Date: 23rd August 2022

App no: 22.0568

Address: Land to rear of Malt Kiln House Malt Kiln Brow Chipping

Proposal: Four new, two-storey residential dwellings

PROJECT				
Proposed Residential Development at Malt Kiln Brow, Chipping.				
DRAWING TITLE				
Traffic Management Plan.				
DATE	SCALE	DRAWN	DRWG No.	REV
June 2022	1:500 @ A3	SDH	MKB/P03	C

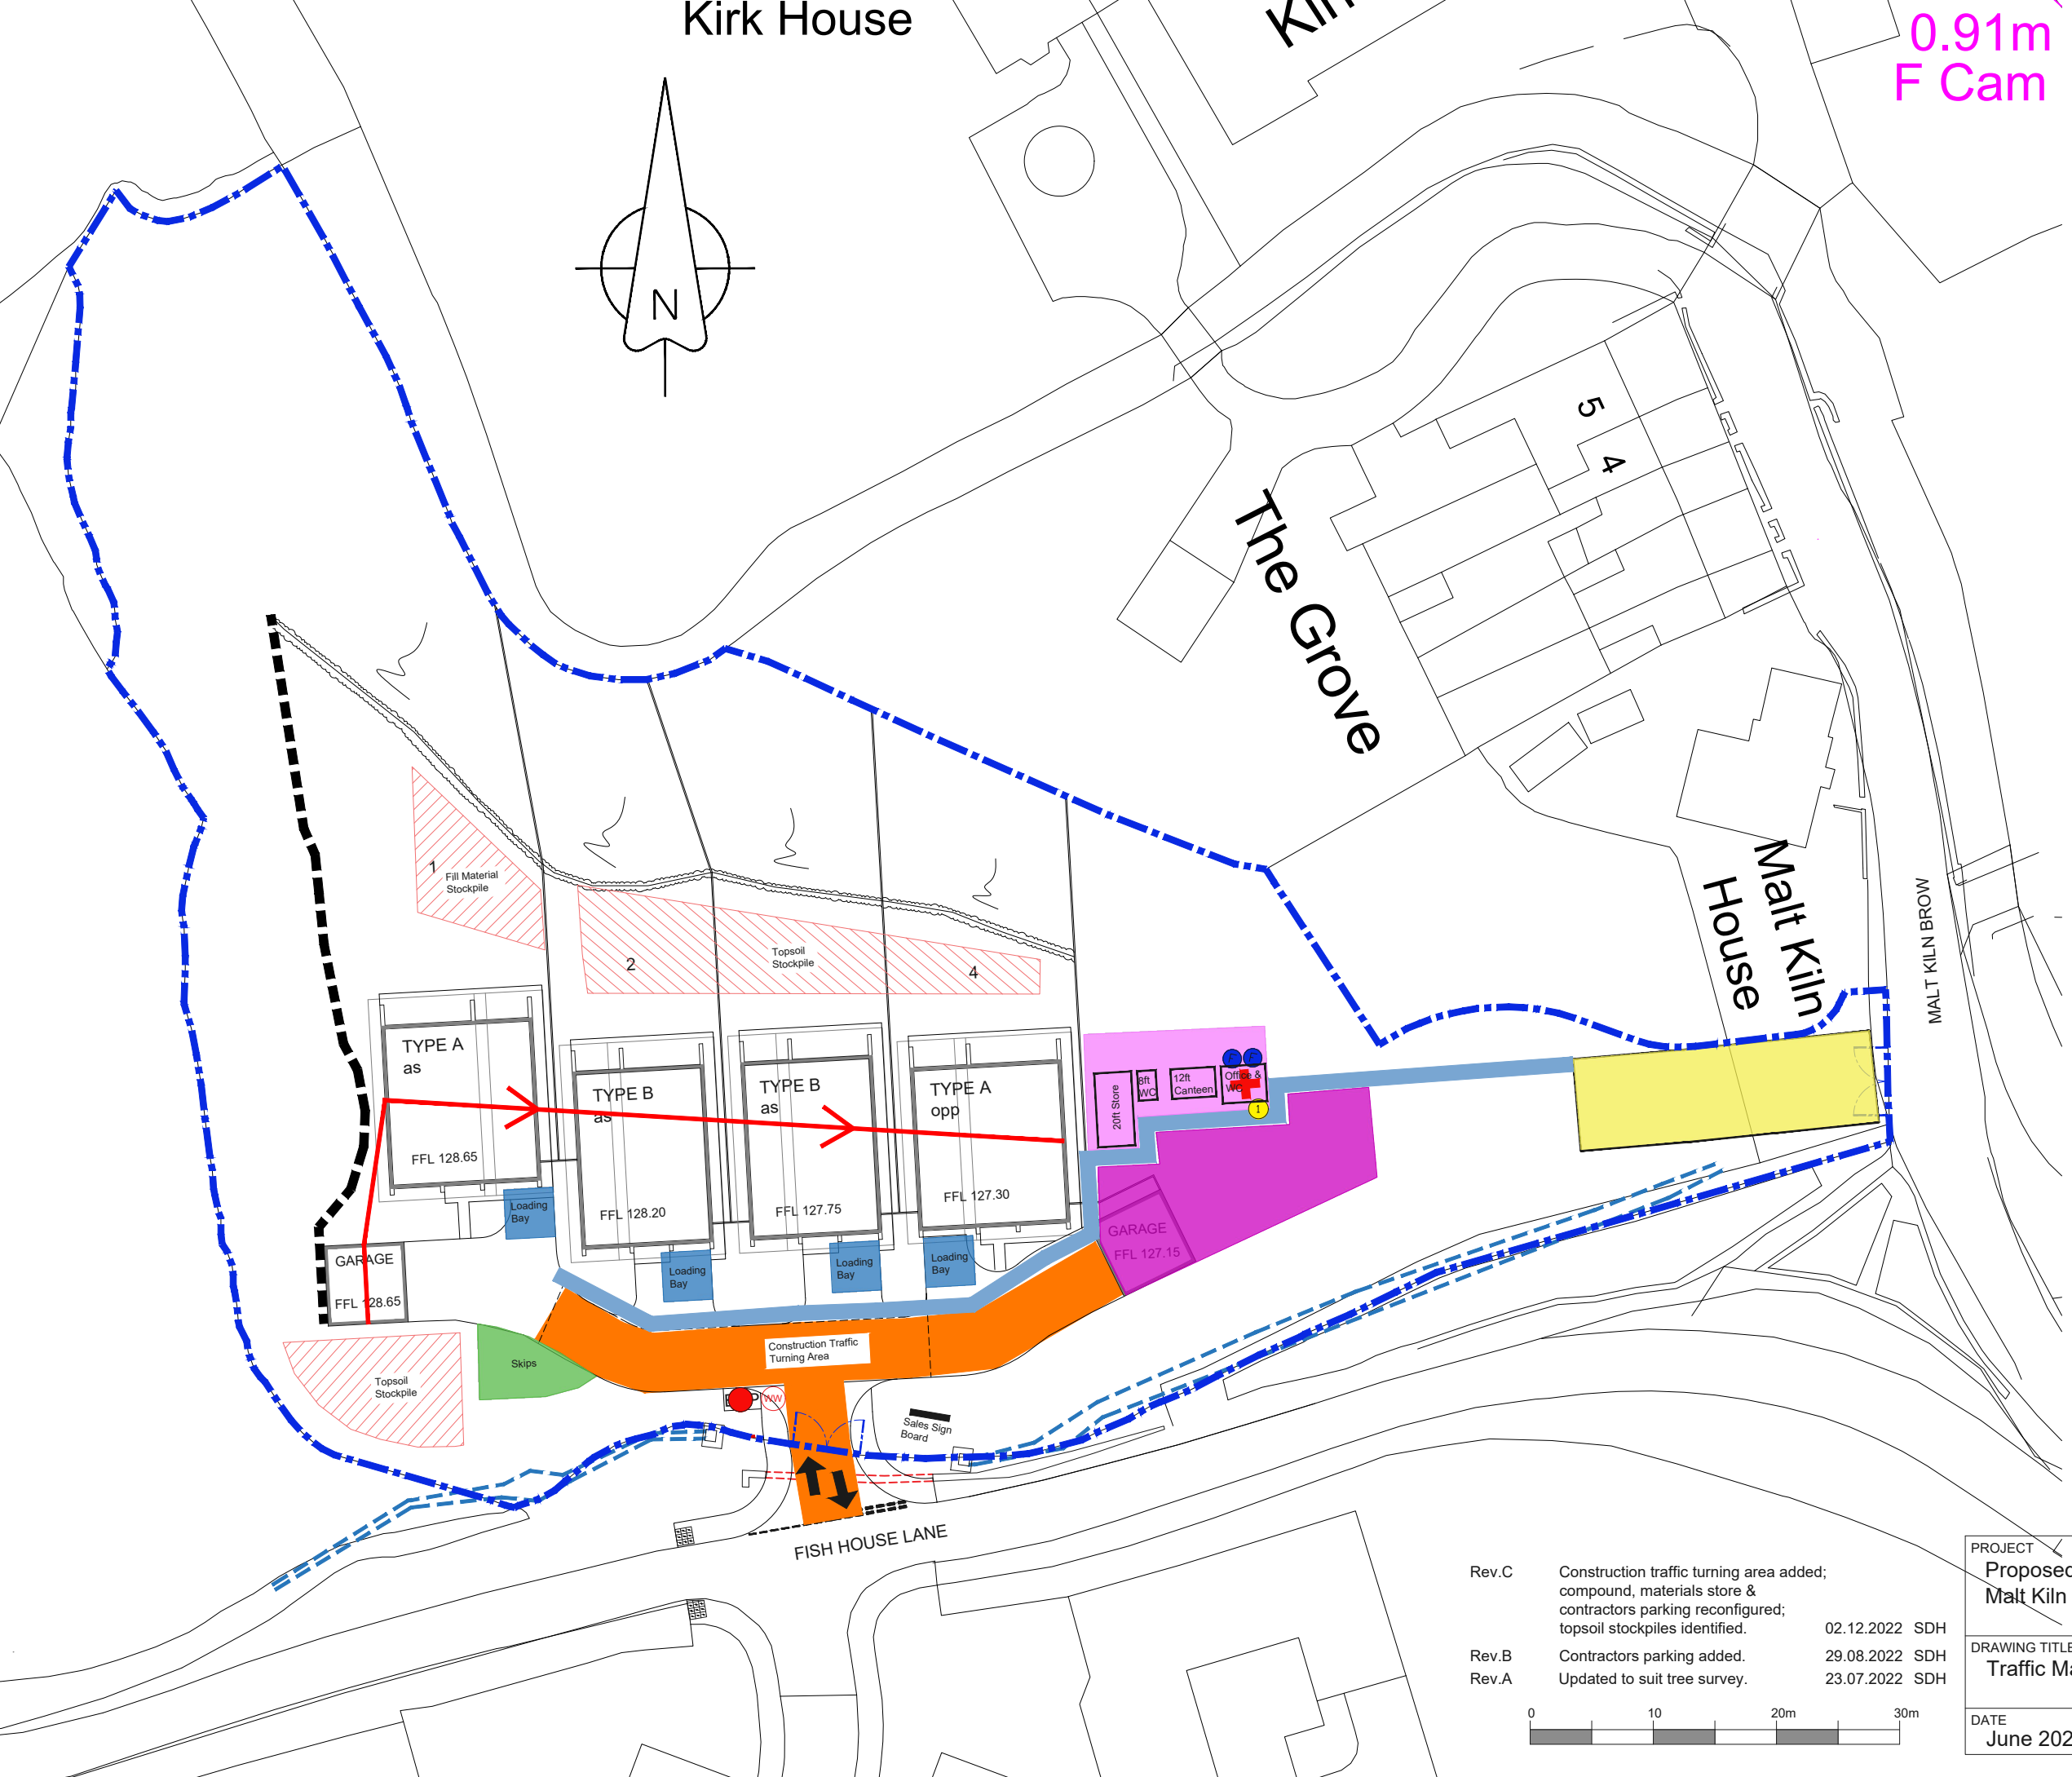
A drawing is submitted titled 'Traffic Management Plan' which shows a compound, storage area and wheel wash on site. Access for construction vehicles is shown entering from Malt Kiln Brow (previously approved access), and exiting onto Fish House Lane, opposite Mills Way via a new access. In addition, an operative car parking area needs to be shown on the drawing.

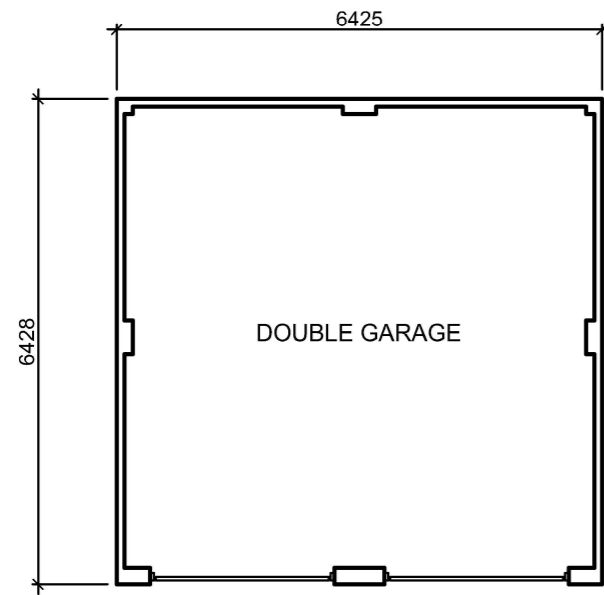
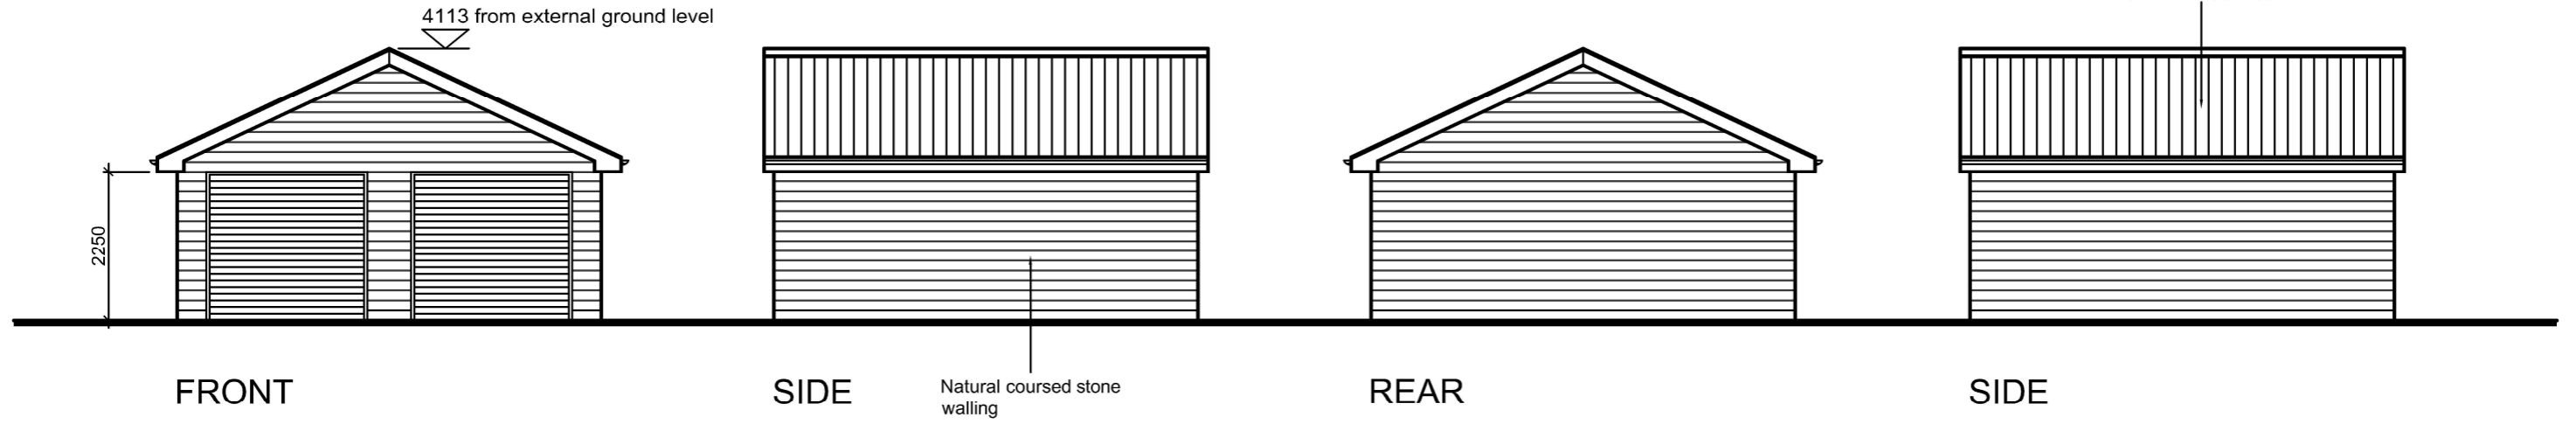
Plots 1 and 4 have detached double garages, measuring internally 6.428m square which is suitable for 2 vehicles and cycles.
